### Application for a Non-Material Amendment Following a Grant of Planning Permission

Proposed single storey side and rear extension. Replacement flat roof to the existing rear extension. Hipped to gable roof replacement and new rear flat roof dormer window. Upgrades to the existing render cladding. New front bay window roof, and fenestration alterations and replacements. Extended drop kerb and front driveway hard landscaping. Demolition of store.(Amended Plan)

23/01031/FLH

01 Proposed Front SW Elevation
Scale: 1:50 @ A1 / 1:100 @ A3

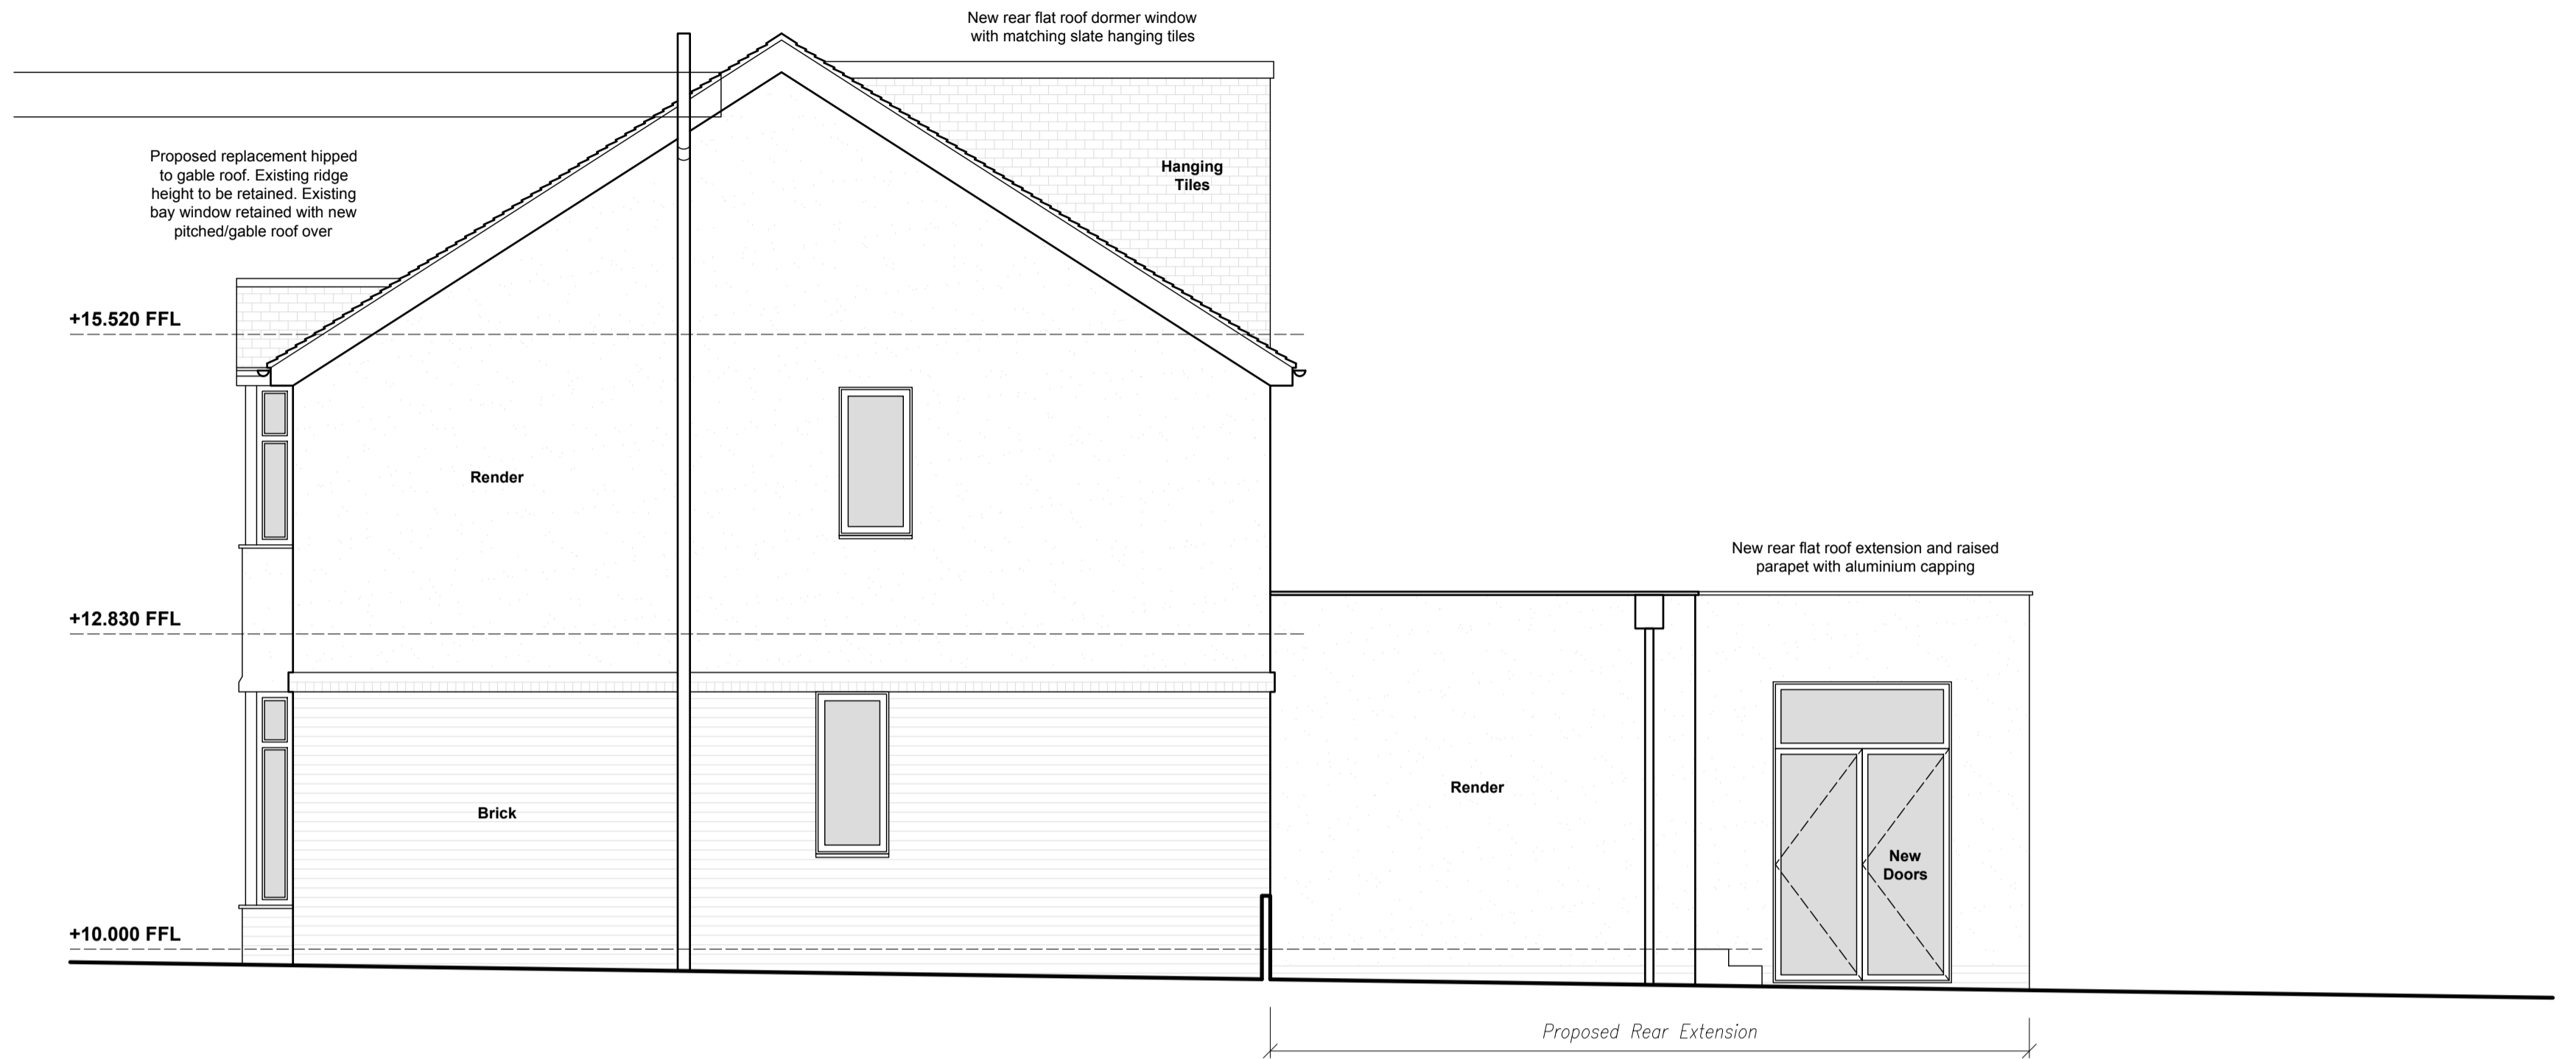
2no additional small rooflights to be installed to the Front elevation

To allow adequate natural light and ventilation to the newly formed second floor accommodation
